THE HILLS SHIRE COUNCIL
3 Columbia Court, Baulkham Hills NSW 2153
PO Box 7064, Baulkham Hills BC 1755
ABN 25 034 494 656 | DX 9966 Norwest

27 May 2022

Your Ref: SSD-15882721

**Comments on Doran Drive Plaza Precinct
LOT 55 in DP 1253217**

Location Diagram

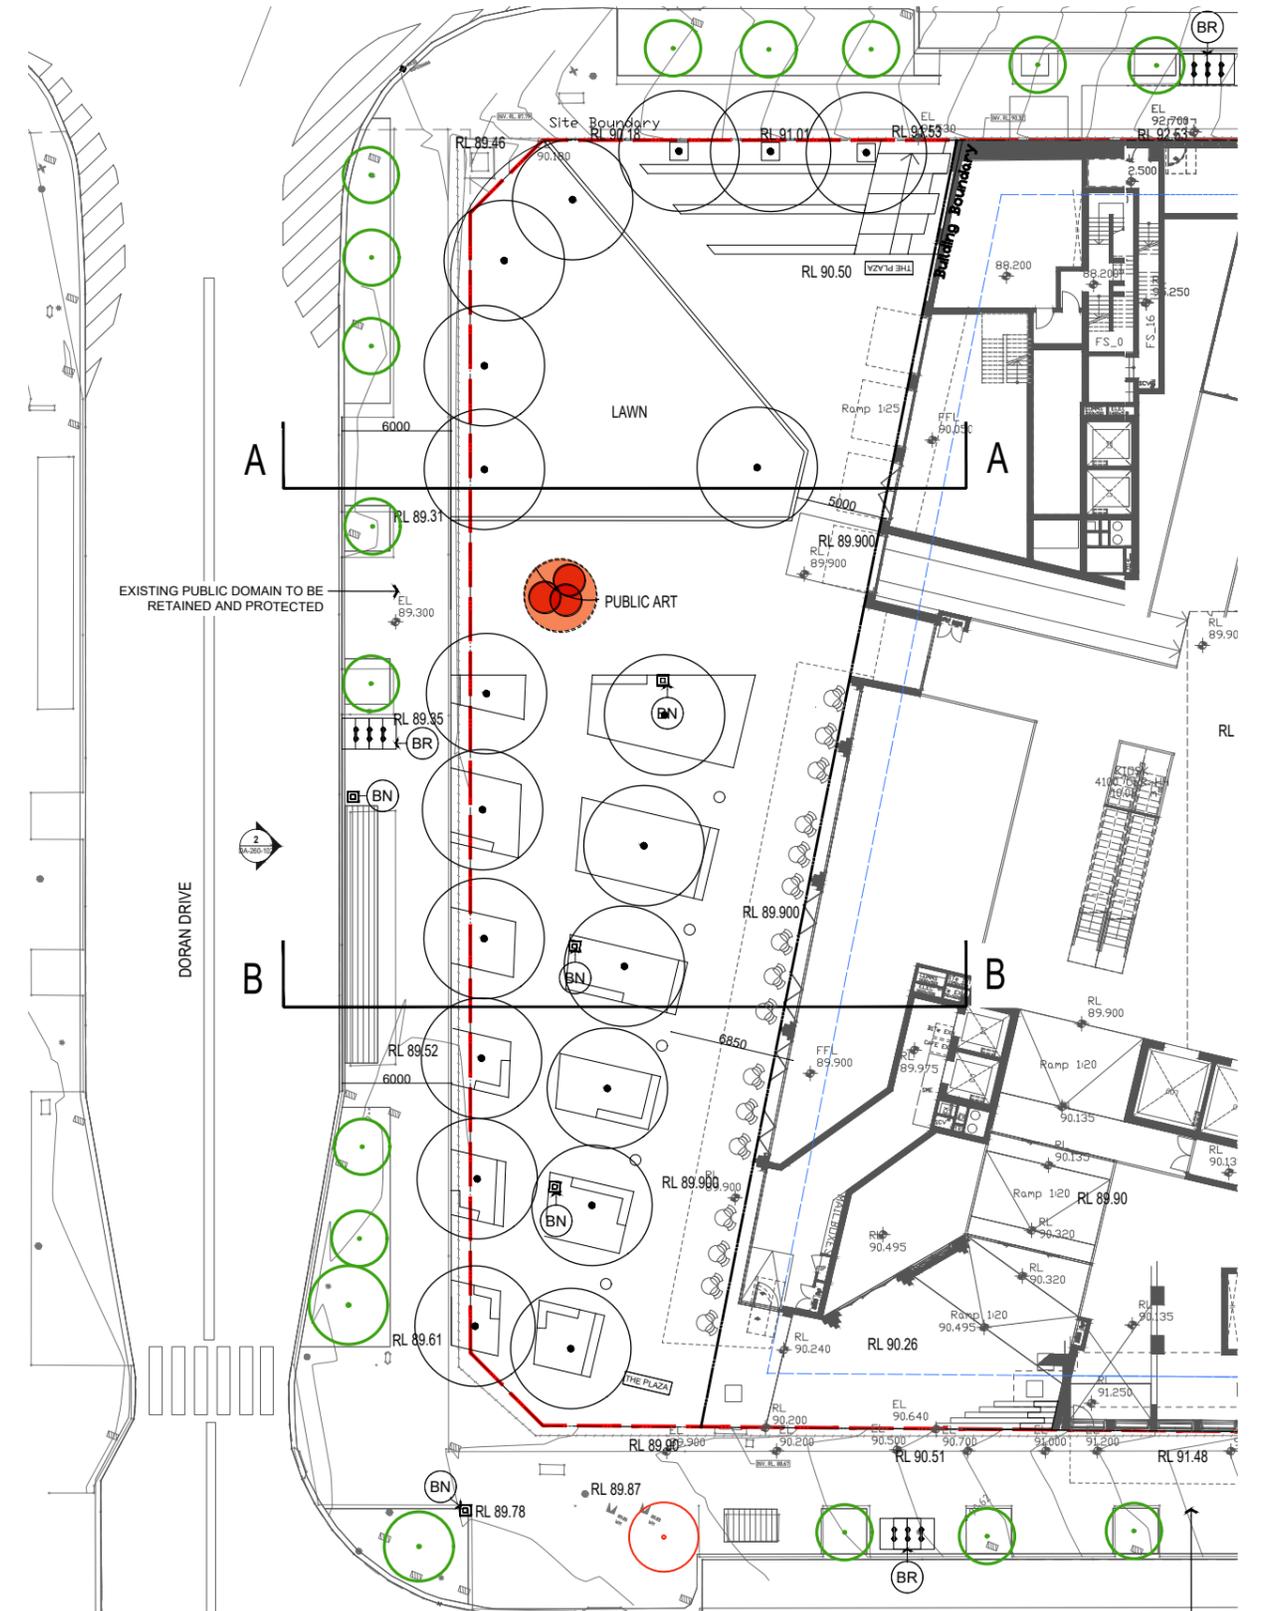
Concern is raised as to the ongoing cost of maintenance that Council would inherit once the site – directly off Doran Drive is handed over to Council to maintain. If any water feature was to be planned for this location, Council staff would prefer a static robust water less feature rather than a high ongoing costly water feature which council would not have the resources to maintain or replace.

Figure 12 – MUSIC Model Schematic

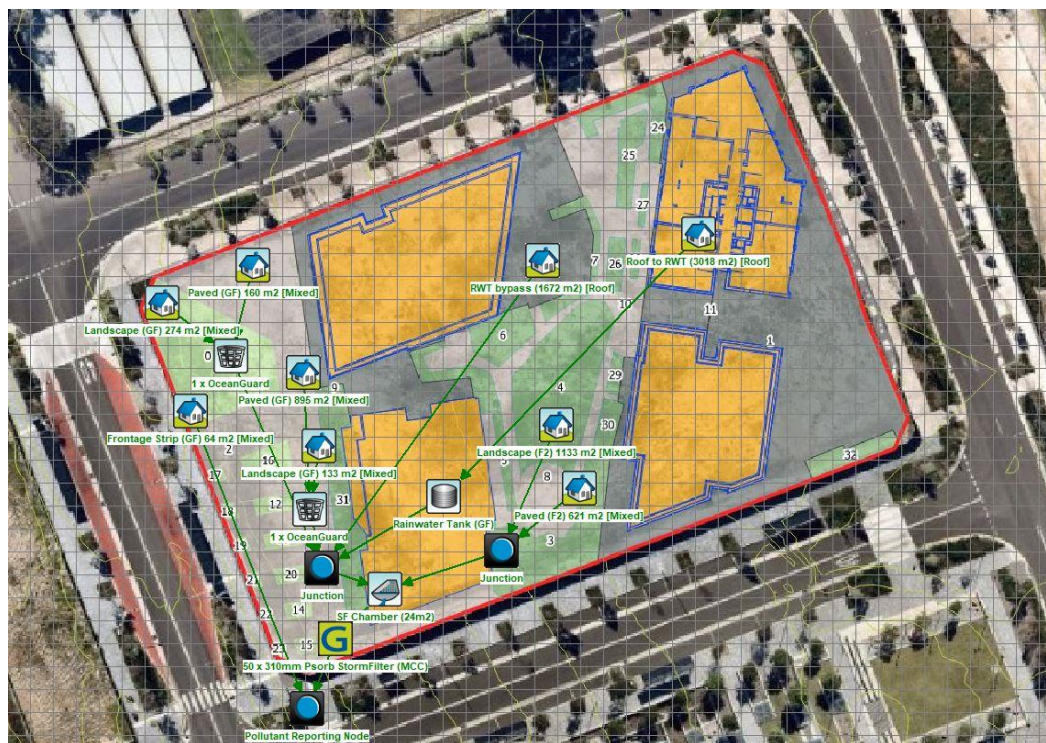
With respect to the MUSIC model, in principle, I have no issues with the design but the MSUIC model will need to reflect the correct total catchment area (i.e catchment B on model is 4540sqm but the draft plans shows 5063sqm), refer to the snapshot below:
